## Post Construction Stormwater Management Applicability Evaluation Form

Part I. Project Information	
1. Project Name: Eagleview Subdivision	
2. El Paso County Project #: SF2248	3. ESQCP #:
4. Project Location: Tax No. 5226000001, 5226000002	Project Location in MS4 Permit Area (Y or N): Y
5. Project Description: The Project Site is approximately 121.20 acres in size. The Project includes 38 lots as well as construction of public streets. Stormwater quality and detention is required for the site and will be accomplished with a regional detention pond and water quality will be provided by two water quality extended detention basin facilities.	
If project is located within the El Paso County MS4 Permit Area, please provide copy of this completed form to the Stormwater Quality Coordinator for reporting purposes; and save completed form with project file.

EAGLEVIEW
 EL PASO COUNTY, COLORADO
 CONSTRUCTION DOCUMENTS
OVERALL DRAINAGE IMPROVEMENTS

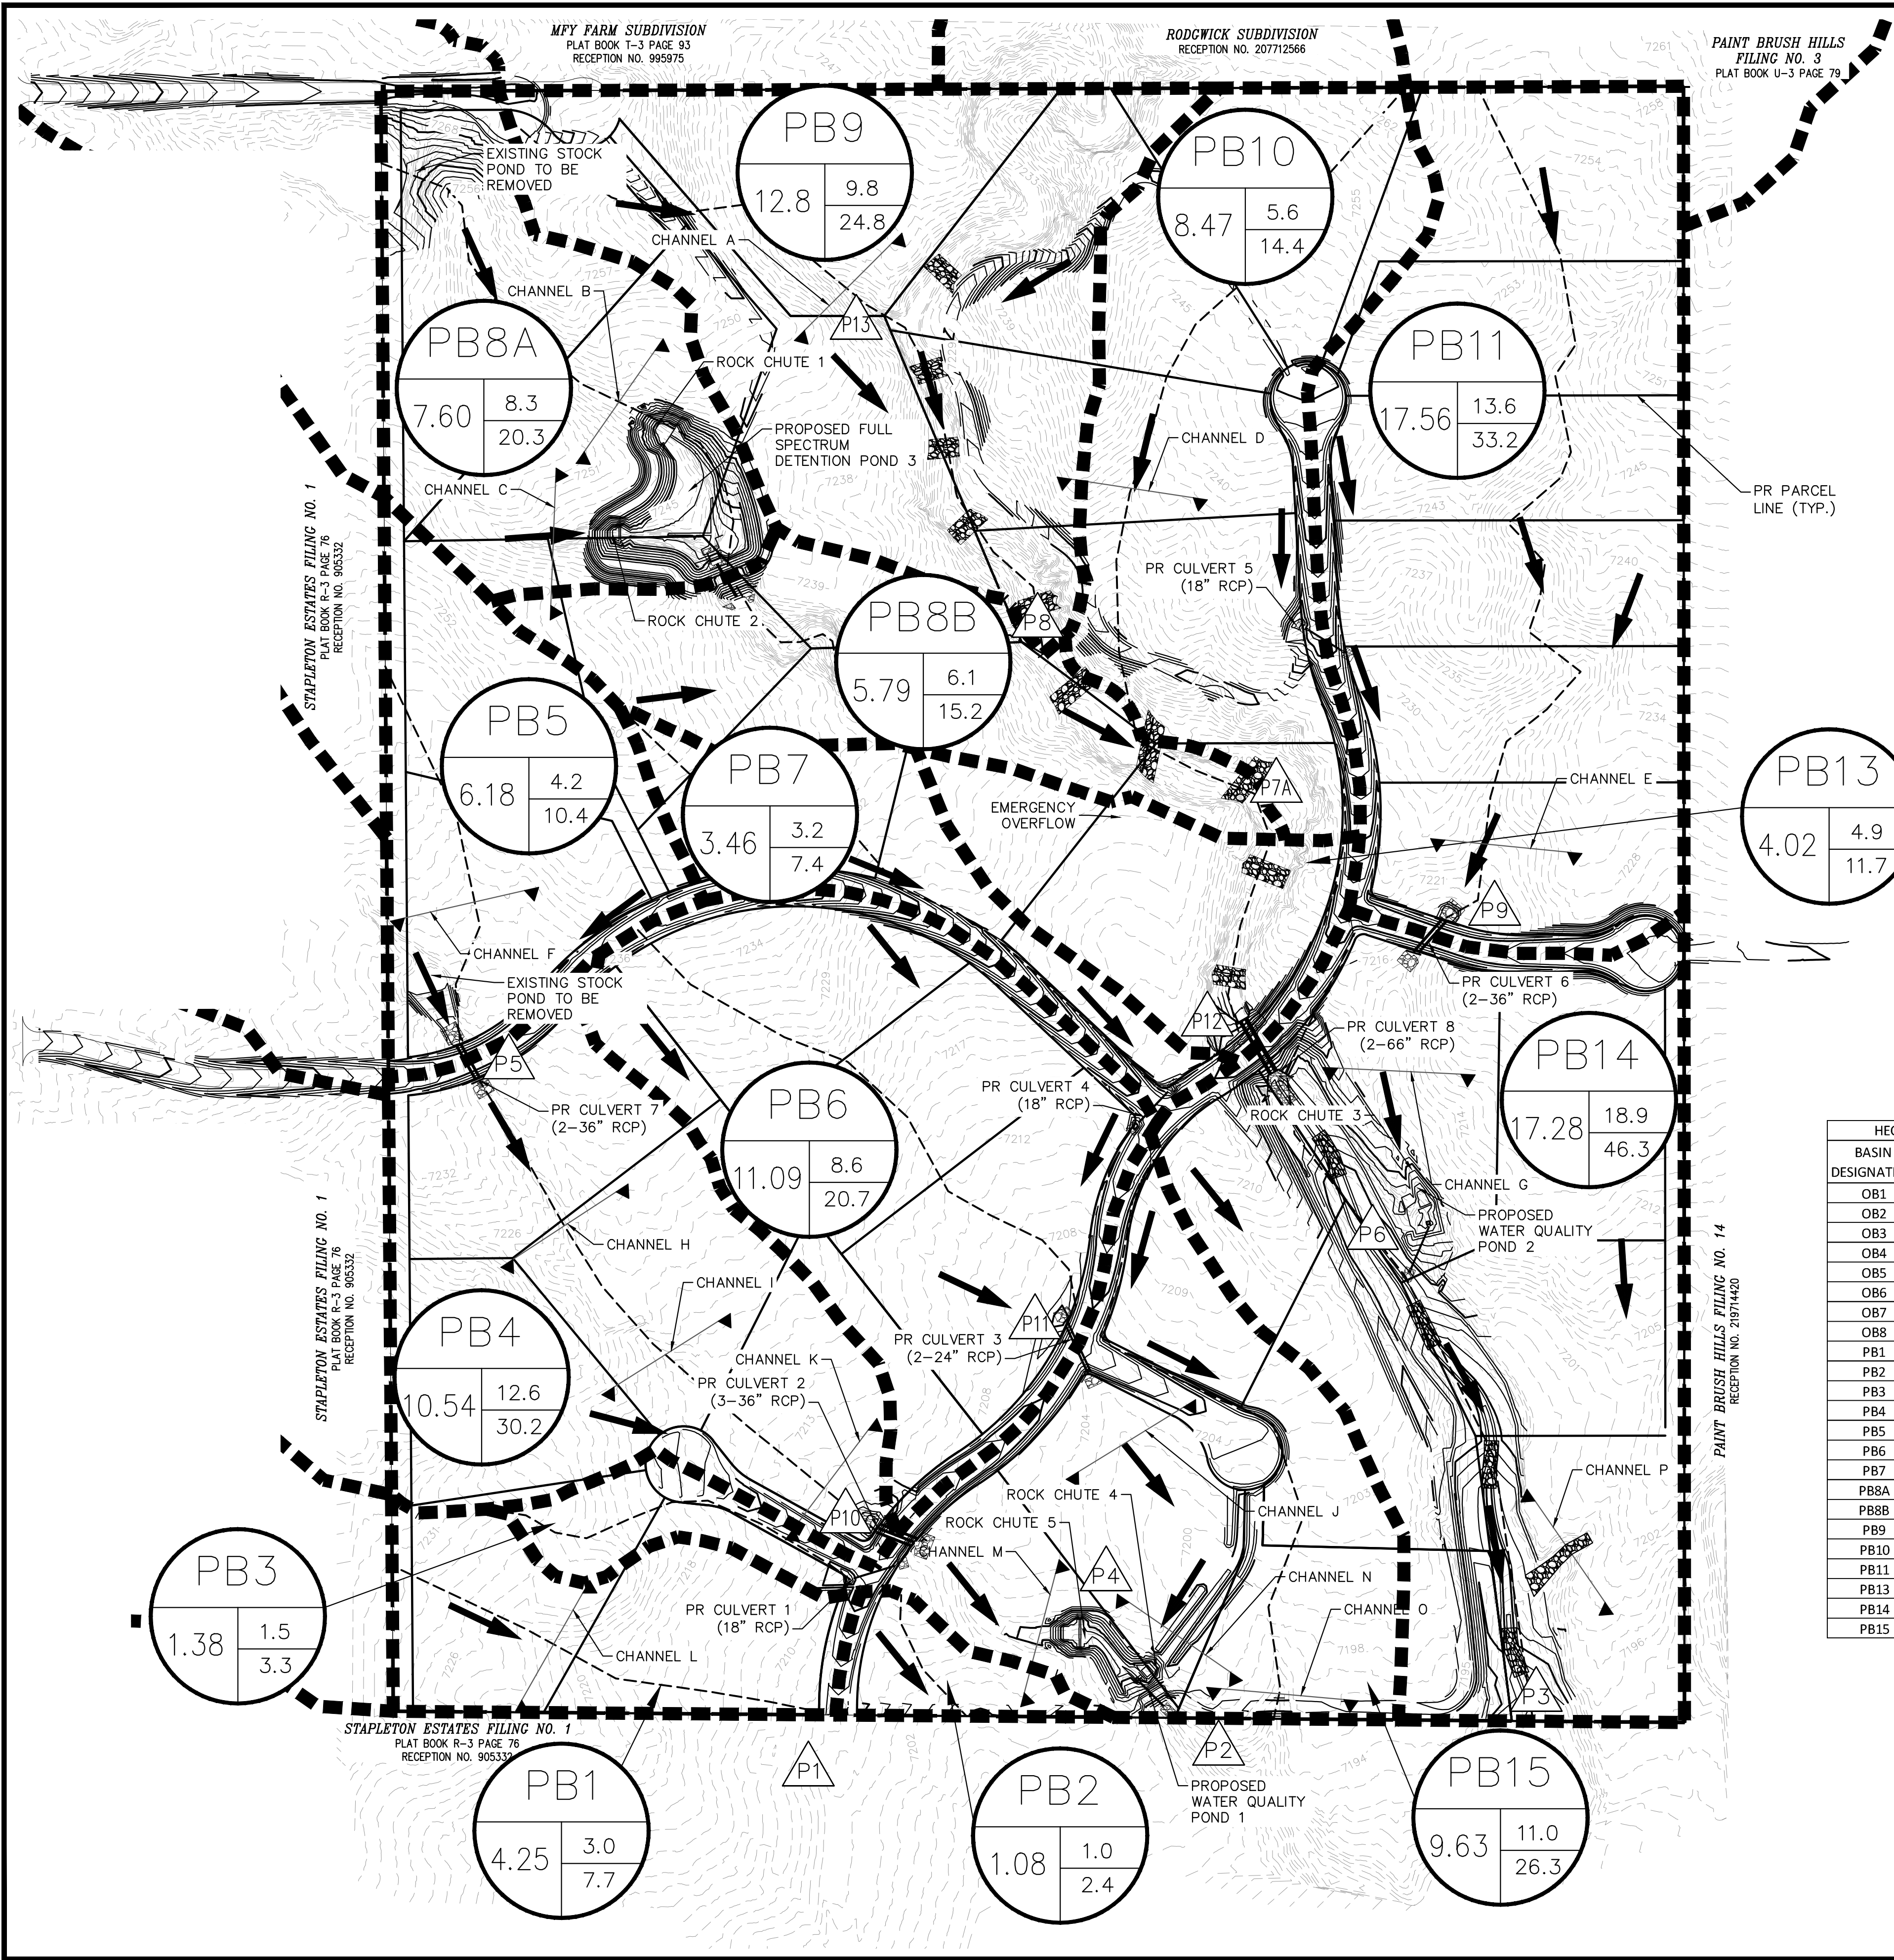
Unresolved comment from Review 1: Per this note, this exclusion does not apply since all roads within the site are new. So revise this item to "No"  
 Review 2 update: this exclusion is not shown on the "Overview Map - PBMP Tributary Areas" on the last page of the FDR.

Unresolved comment from Review 1:  
Revise to "Yes" per drainage map in last page of FDR.

Review 3 update: or leave this as "No" if the FDR drainage map text is incorrect (see my comments in the FDR).
